From: planning.comments@york.gov.uk
Subject: FW: Planning Application Consultation 22/02146/FUL at The Yews Stamford Bridge Road
Attachments: ufm94_STDCN_-_Standard_consultation_letter.pdf; Waste Information for Developers 01 07 2022.pdf

From: Heron, Stuart <Stuart.Heron@york.gov.uk>
Sent: 24 October 2022 13:41
To: Bell, Victoria <Victoria.Bell@york.gov.uk>
Subject: FW: Planning Application Consultation 22/02146/FUL at The Yews Stamford Bridge Road

Site Block Plan as Proposed

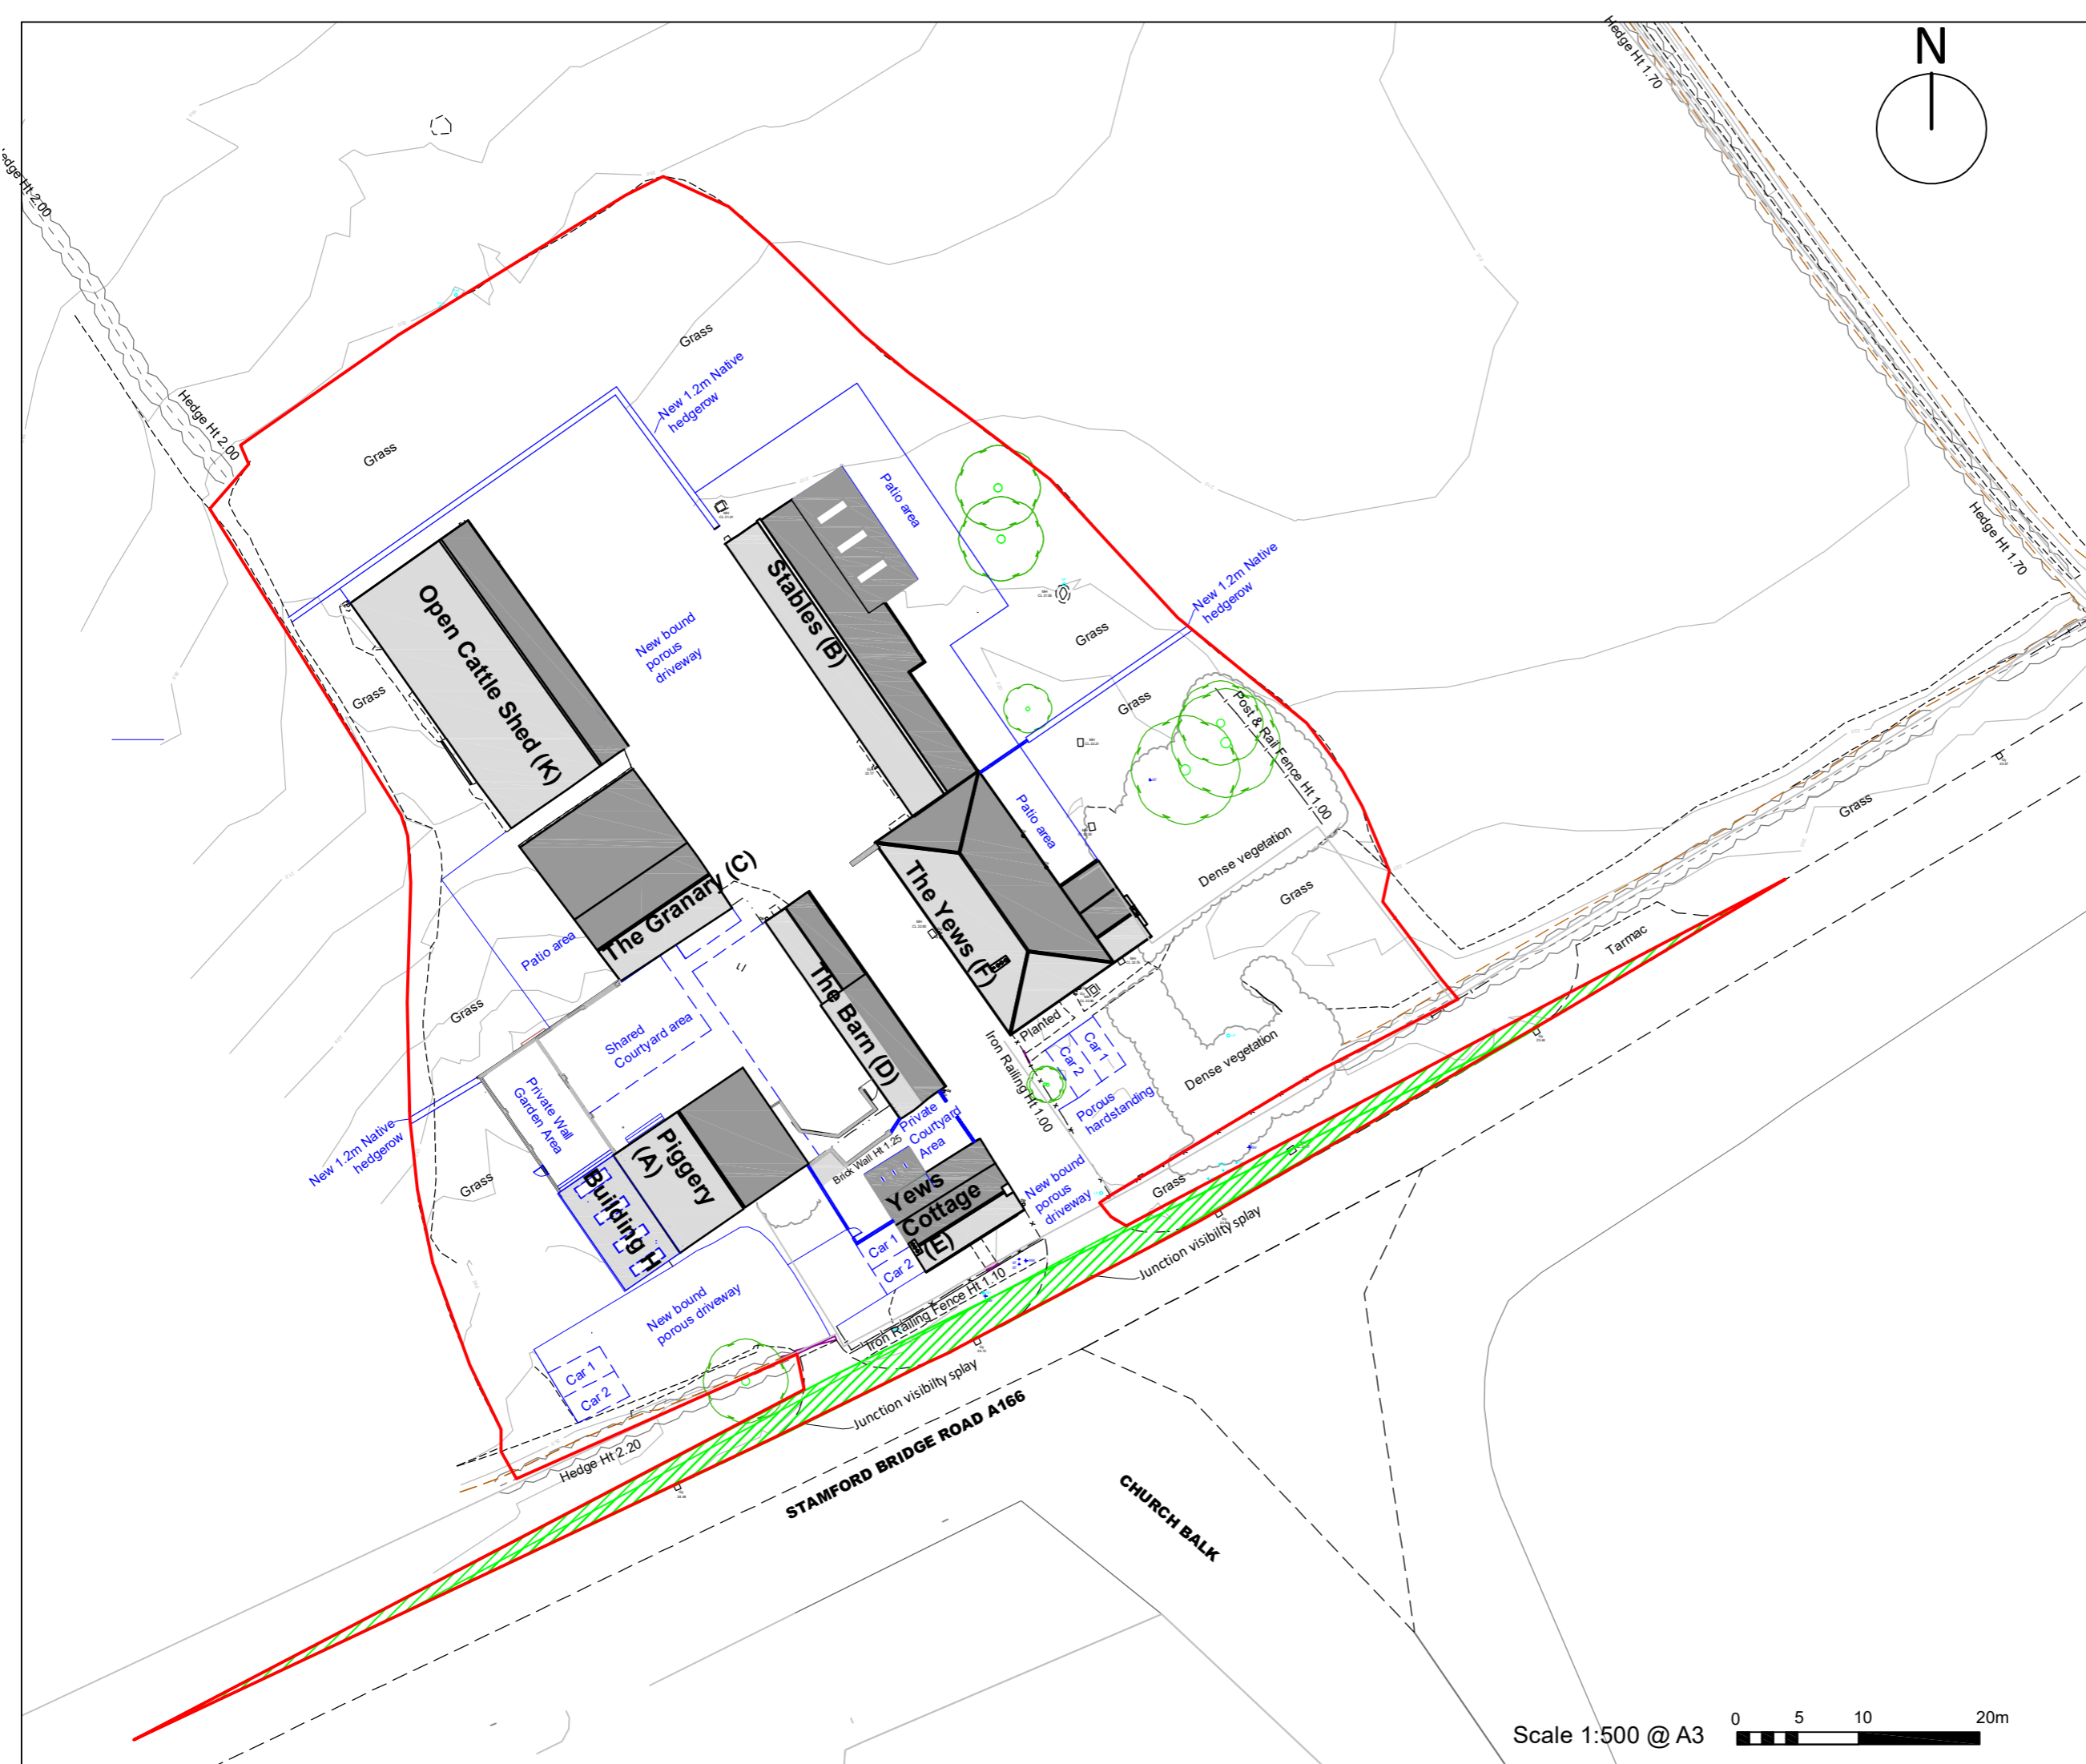
Hello Victoria,
I can see no reference to waste management within this planning application, therefore it is not acceptable.

The developer should revise their plans to incorporate a waste management strategy for the site, paying attention to , but not limited to the following:

CYC do not access private roads for new developments to collect waste. Waste from this site will be via a Central Collection Point, residents are responsible for moving their bins to the Central Collection Point and returning them to their property. Each property is entitled to an individual general household waste bin and use of communal recycling bins

If a Central Collection Point is needed, the developer is required to provide an appropriate place and hardstanding on which to place these bins for collection. Please note - we do not collect Kerbside recycling boxes from Central Collection Points - communal bins will be required. Consideration must be given to the distance residents are to move their bins to the Central Collection Point and return to their properties

The Central Collection Point should be located as near to the road as possible with a flat even surface between it and the vehicle collection point, (n.b; not gravel, cobbles, kerbs etc.) to reduce the distance the collection crew has to travel to empty the bins

The communal recycling entitlement for 4 dwellings is 2 * 360 litre bins. These must be presented at the Central Collection Point, it is acceptable if these bins are permanently located at the Central Collection Point.
